Re : Planning application K/10/18/HH La Casa 57 Coastal road

We would like to strongly object to the to the above planning application. We are the owners of 55 Coastal road which is the house immediately to the east of this property.

Roof Plan as proposed

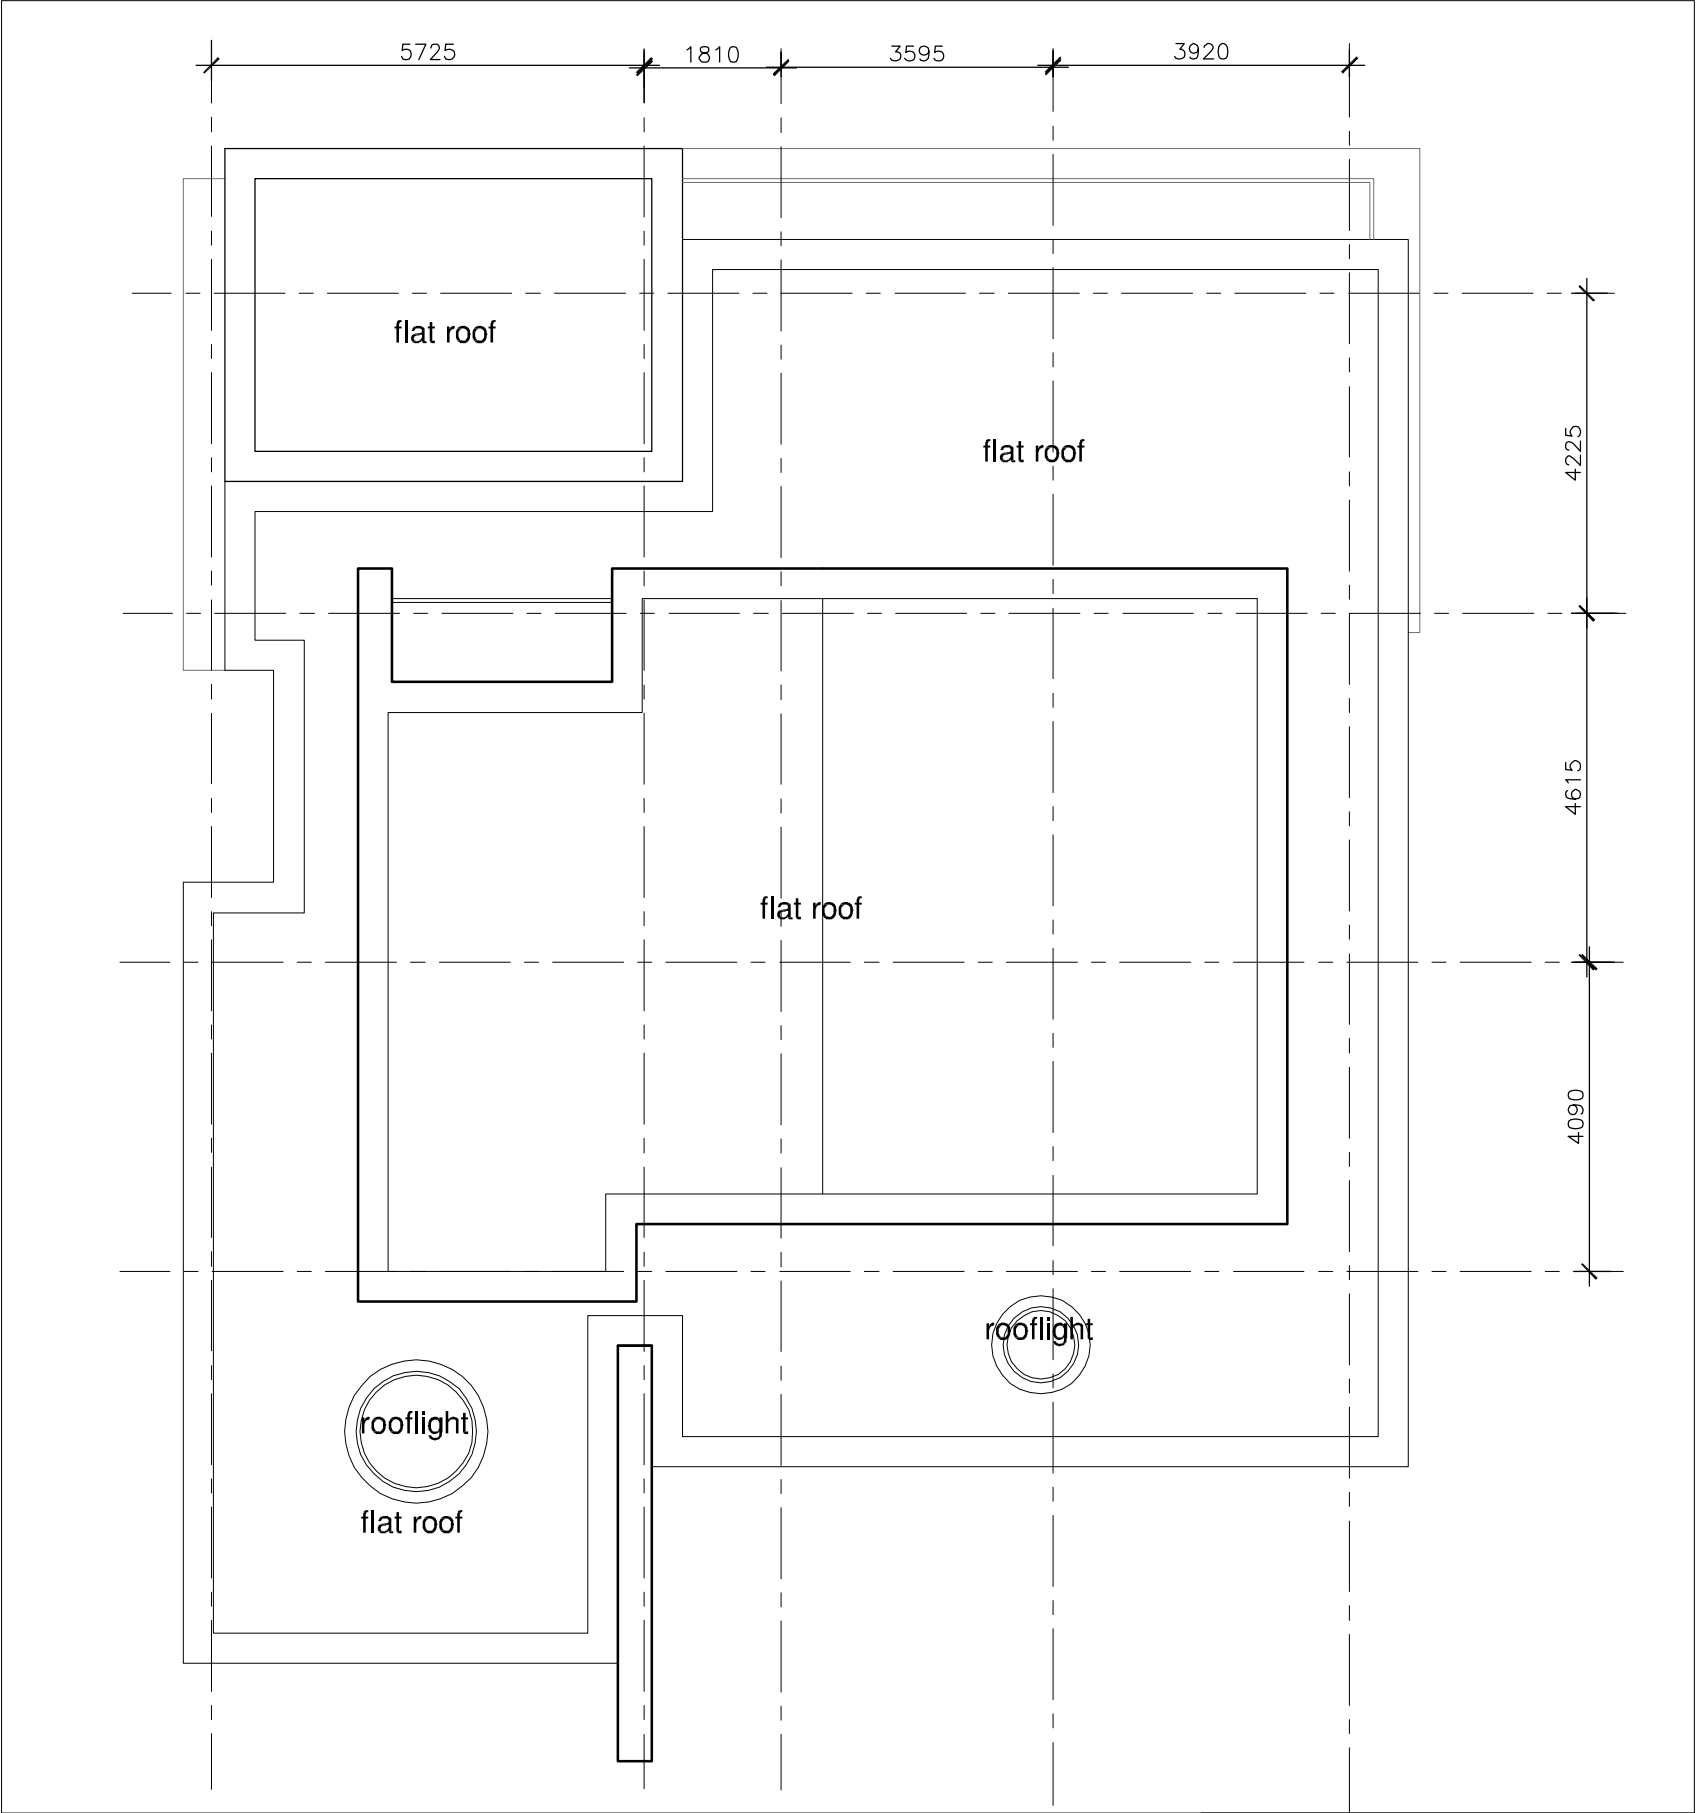
The overdevelopment is made worst by the proposal of an increased roof height which is even more detrimental as it is a flat as opposed to a pitched roof which both affects light to adjoining properties and has an oversized appearance.

Site Plan as proposed

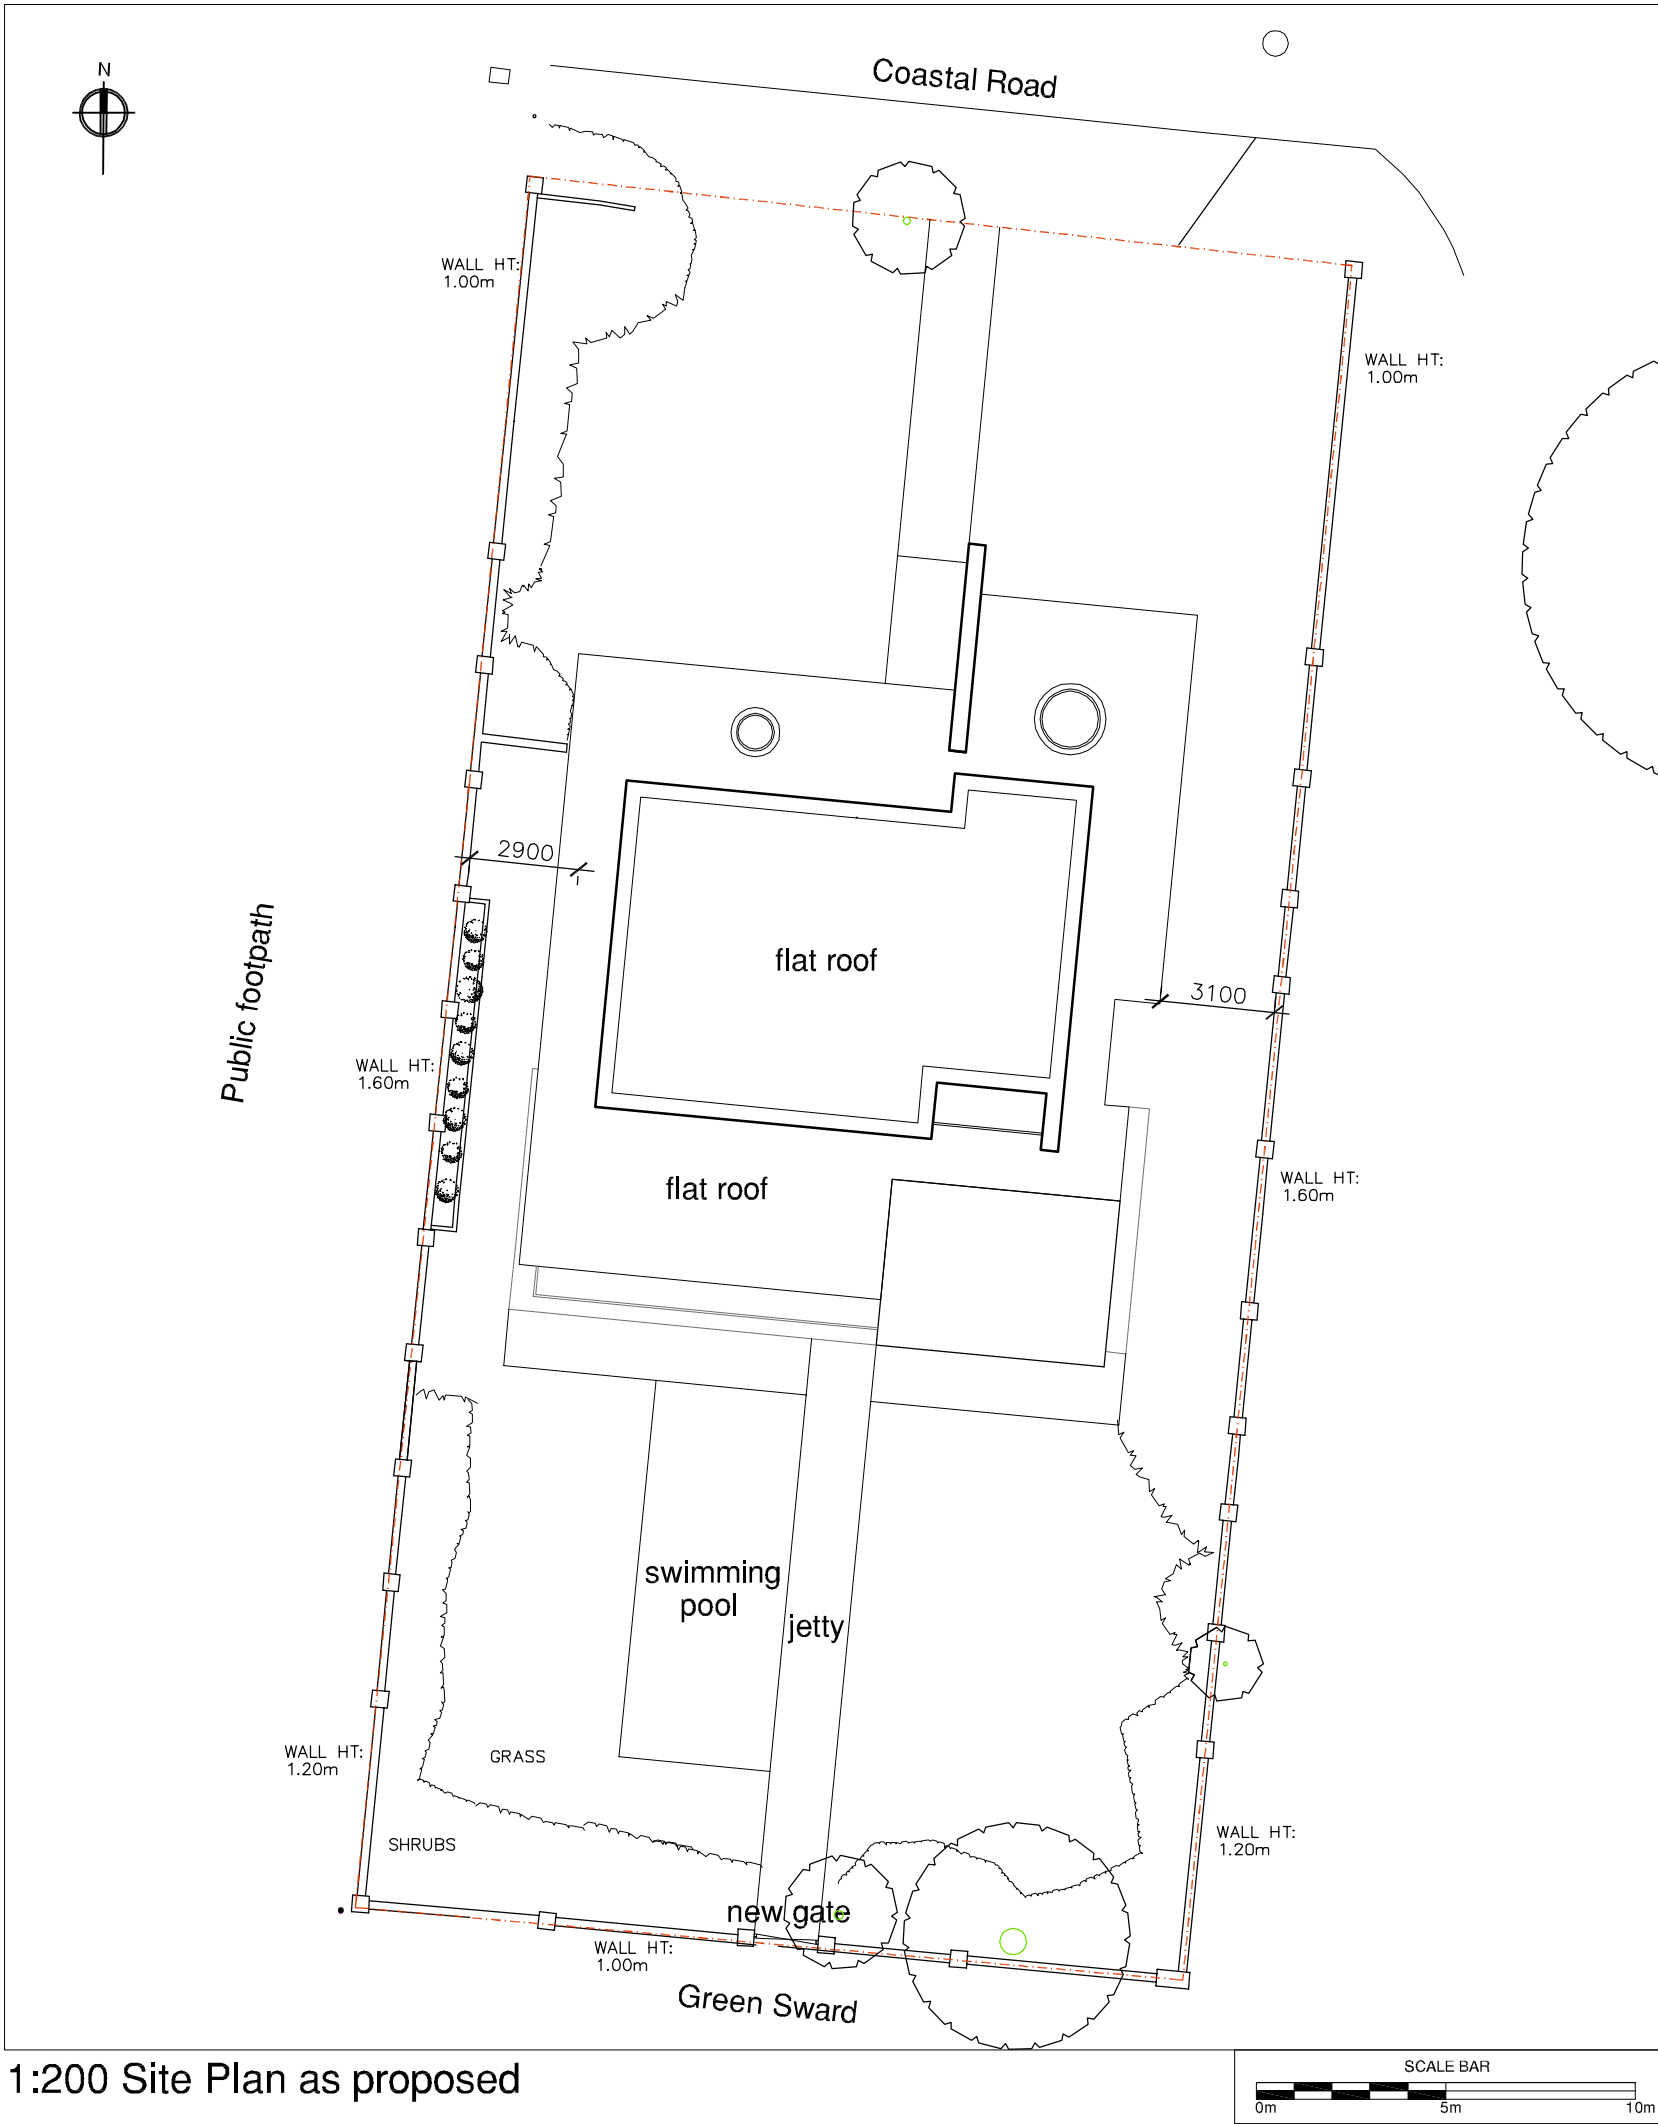
Thirdly this proposal will be detrimental to the visual amenity of the neighbourhood as it is so out of keeping with the scale of the majority of local properties in Coastal road and where its overall footprint is proposed to be double that of our property. The proposed extension to the north side of the property is large enough in regards to the current property but the extension to the south will set a very bad precedent by pushing out the current building line well beyond the vast majority of existing properties.
